Application No: EP/57/21/PL
Site Address: Land rear of Beechlands Cottages Beechlands Close East Preston BN16 1JT
Description of works: Demolition of existing buildings and erection of 2 No. dwellings with associated car ports/parking, alterations to existing access and relocation of staircase to flats. This site is in CIL Zone 4 and is CIL Liable as dwellings.

Thank you for your internet representation made on 23rd June 2021 which has been recorded as an objection with the comments as follows:

Elevations of new stircase to existing building

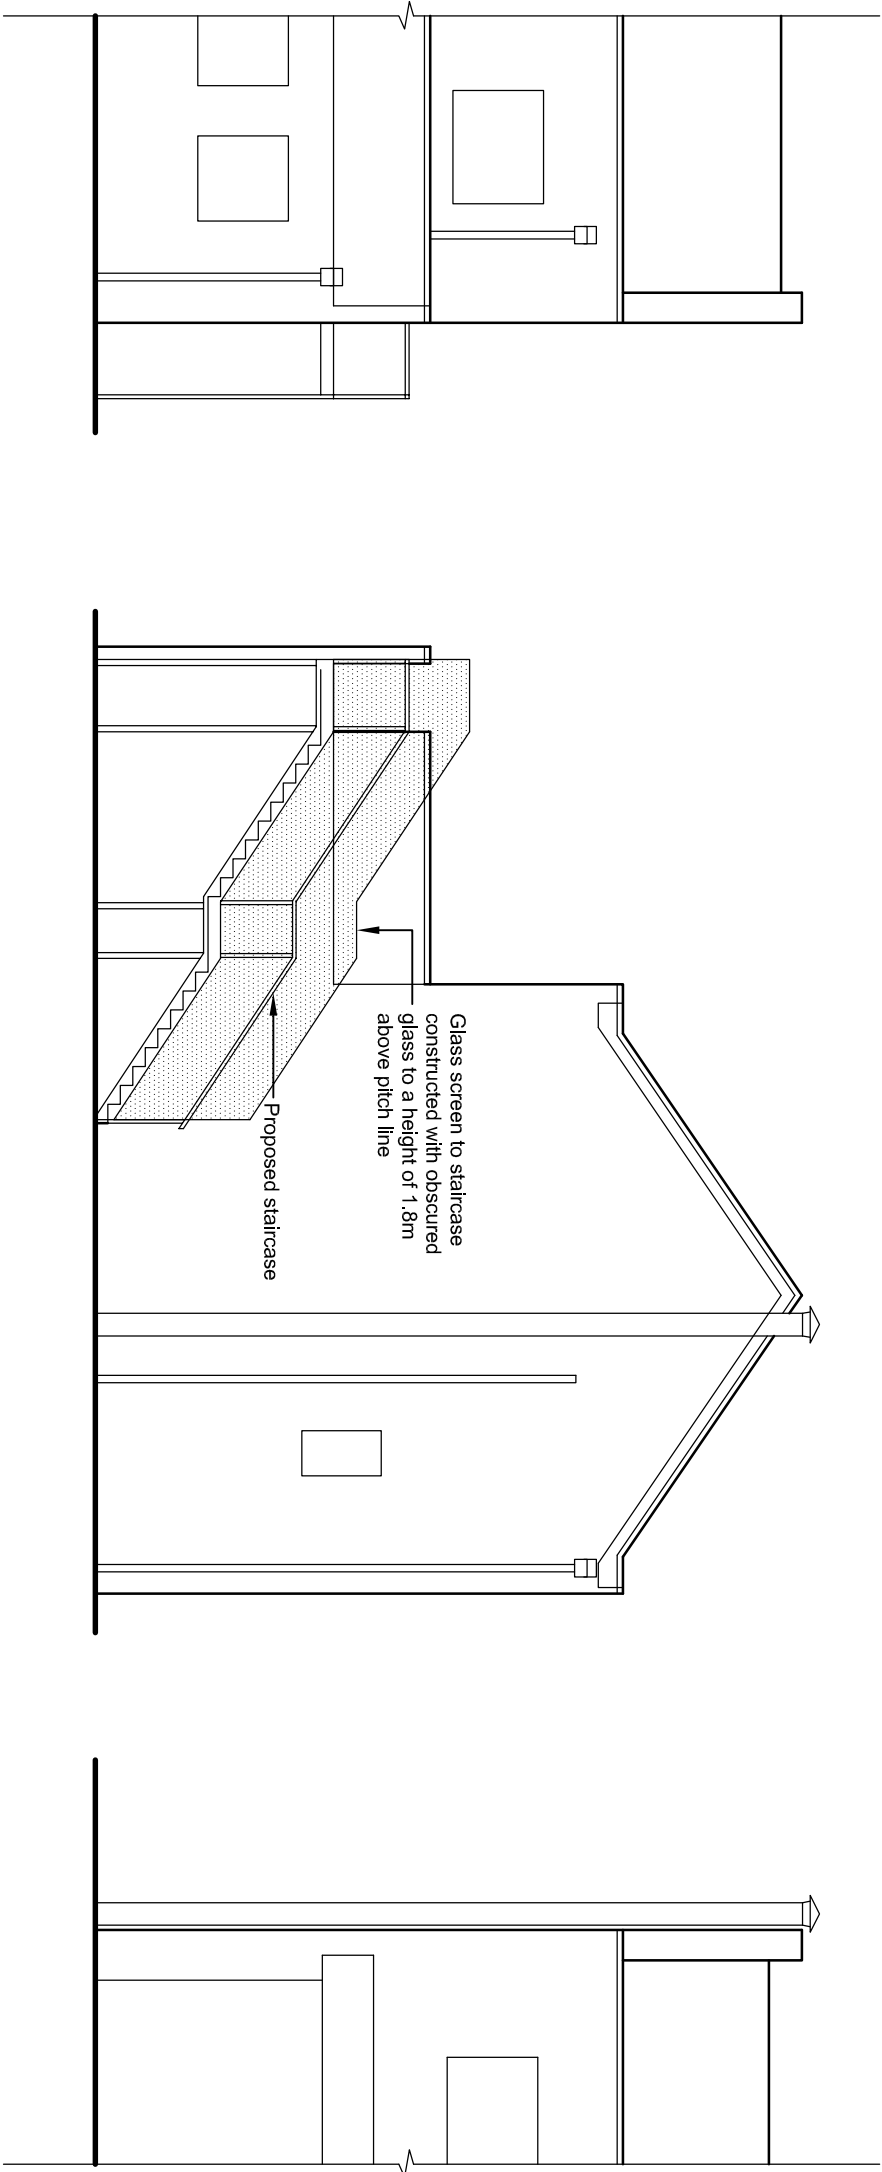
The committee remained concerned about the ability for emergency vehicles to access the site, not only the proposed new properties but also the rear of the existing flats above the shops in North Lane/Sea Road. The committee was concerned about emergency exit for the residents of the flats above these shops if the escape staircase is moved to one end of the building this will be an unnecessarily long route for some residents.

DRAWING TITLE:
Proposed Plans and Elevations

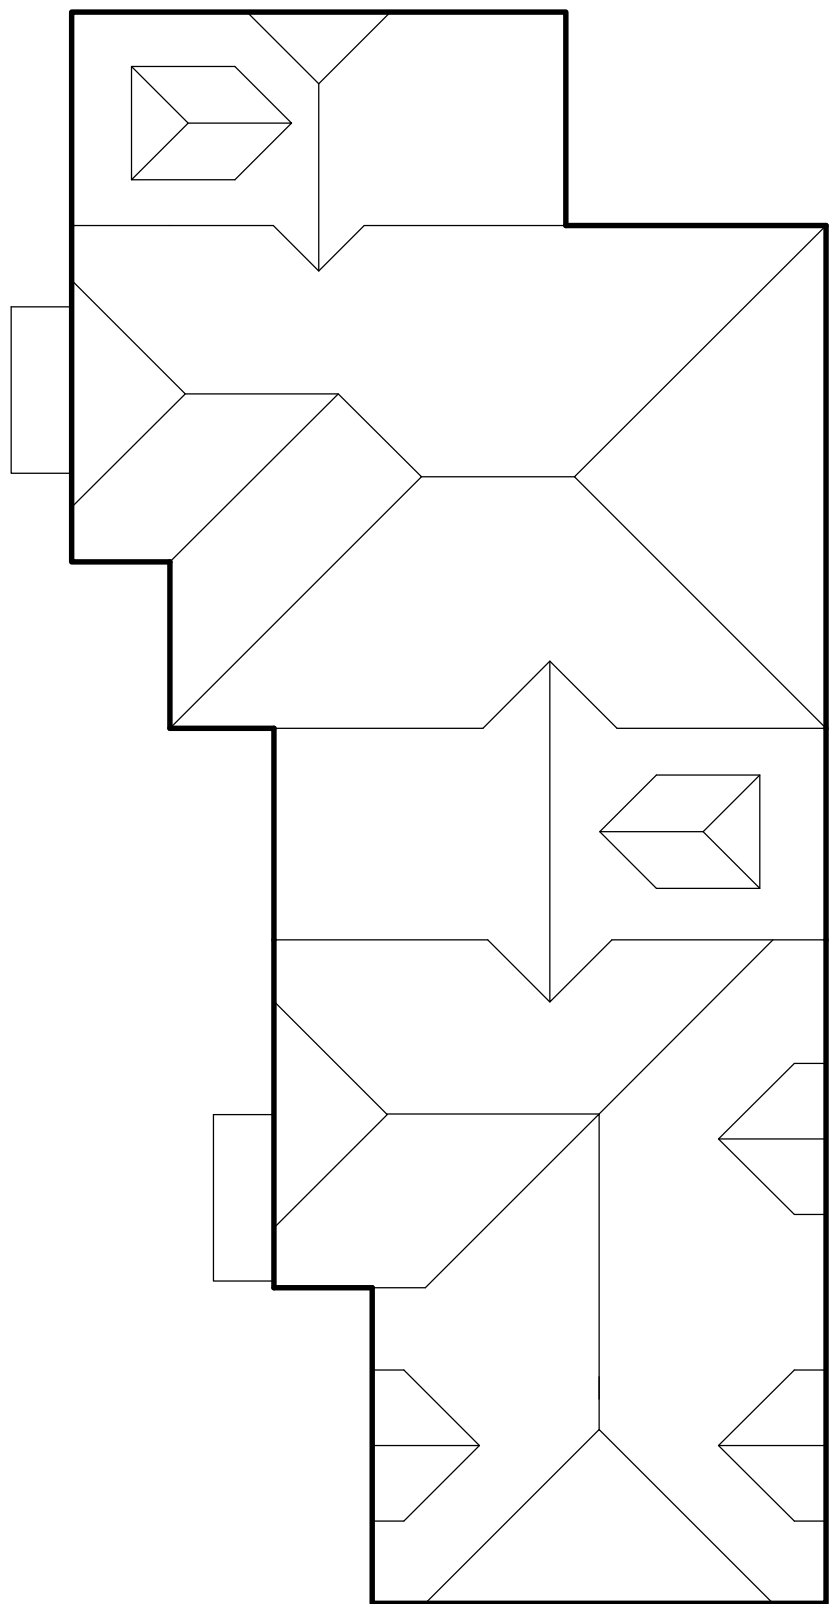
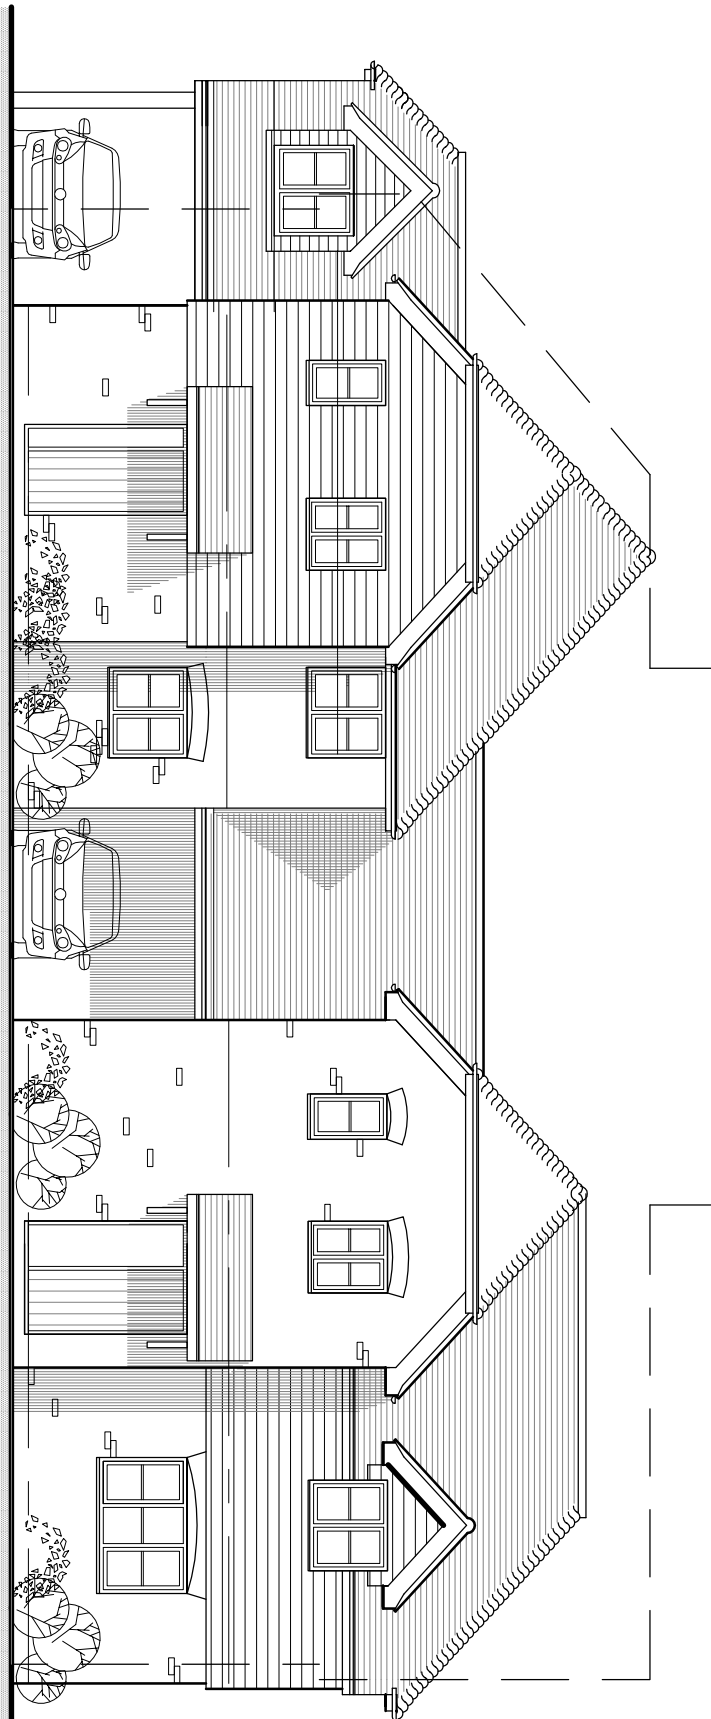
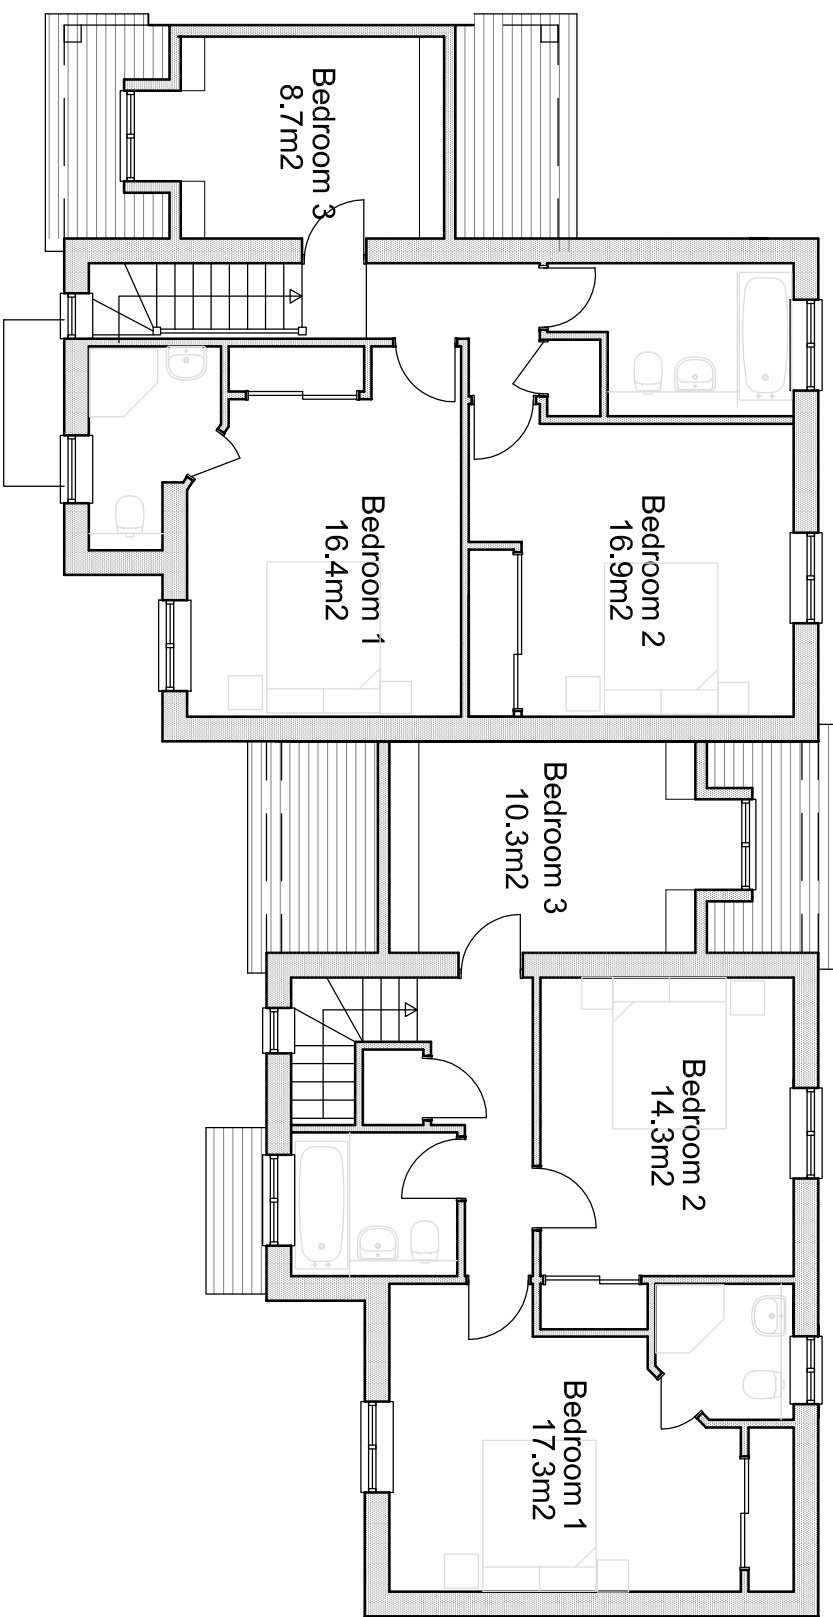
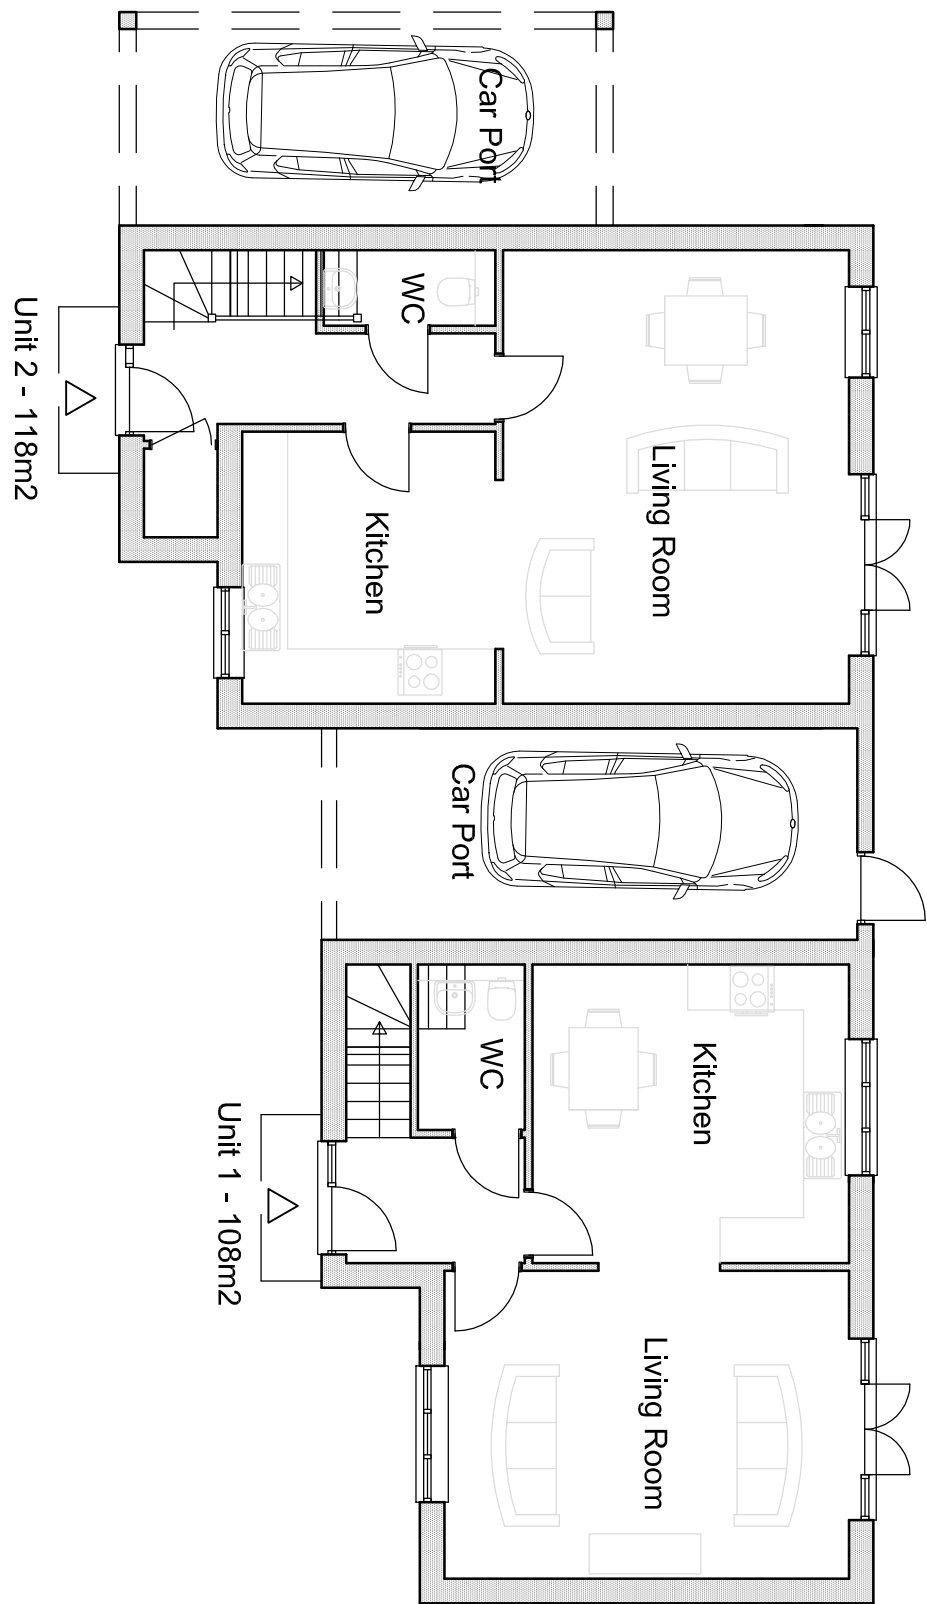
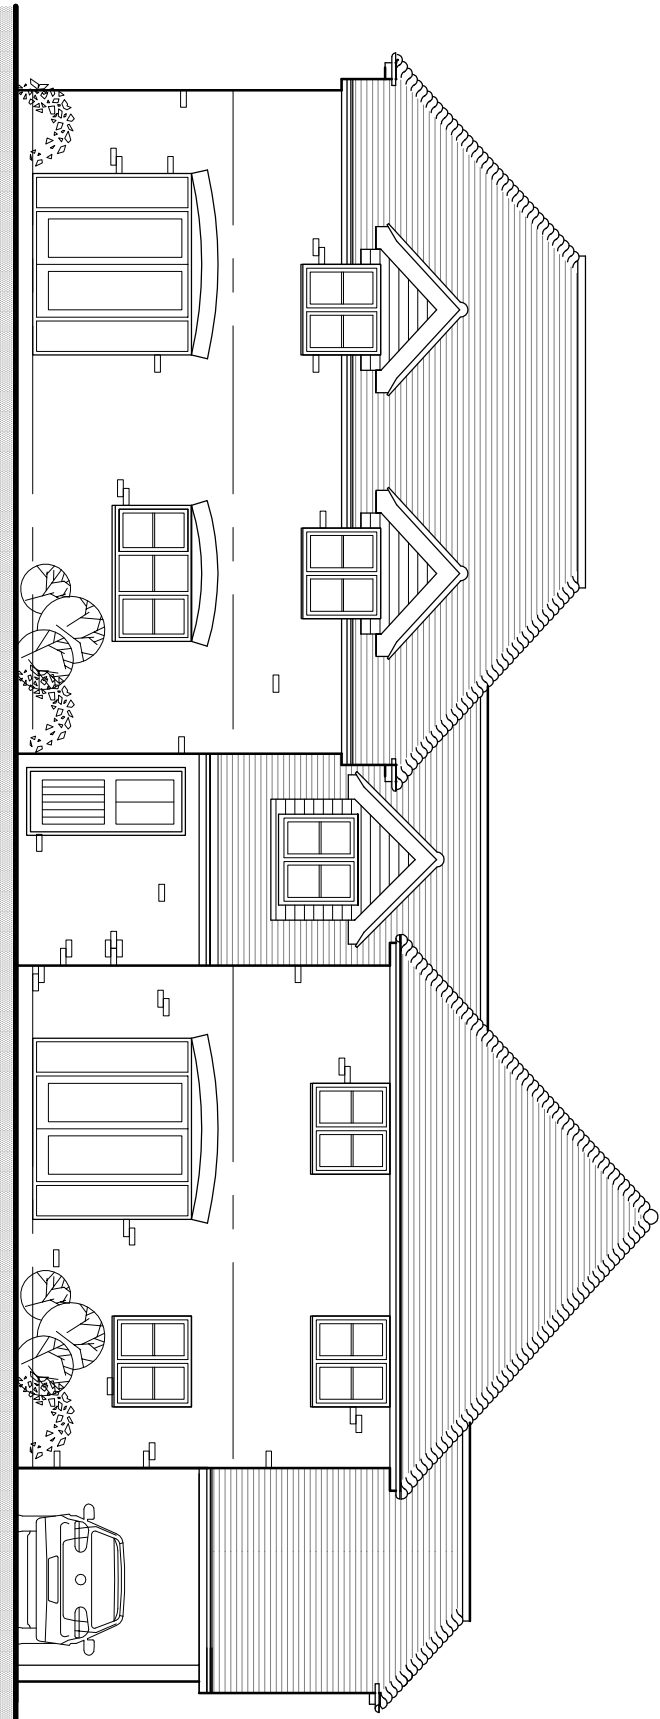
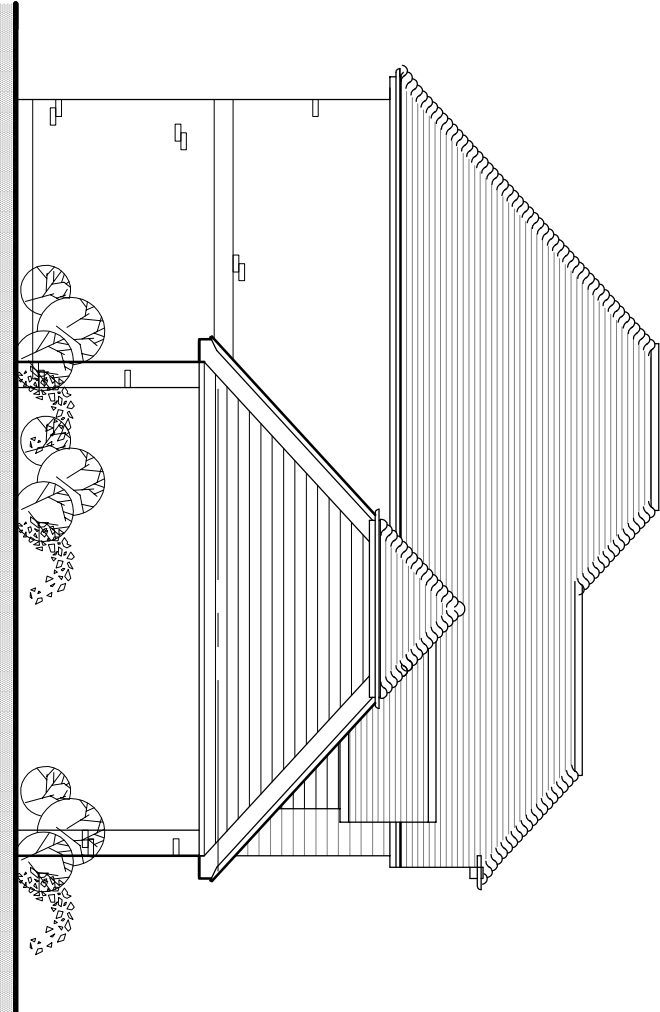
The proposed development would represent an overdevelopment of the site which would appear unduly cramped and would therefore be contrary to Policy D DM1 within the Arun District Local Plan, Policies 1 and 2 of the East Preston Neighbourhood Plan and the National Planning Policy Framework (NPPF).

The committee was concerned about the provision of just four parking spaces for the two proposed properties. The plans suggest a total of ten people could live in these properties regardless of parking calculators, is it realistic to believe those ten people may only have five cars between them? If the proposal went ahead, existing car-parking would be lost in an area in which on-street parking is already at a premium.

The committee felt the design of the building was contrary to the National Planning Policy Framework though better than the previous iteration, the design still feels awkward and not in keeping with nearby properties.

There was also concern about the distance the new properties will be from the back of the existing Nos. 1-4 Beechlands Cottages. The proximity of the new properties both to Beechlands Cottages and other nearby properties could result in a loss of amenity.
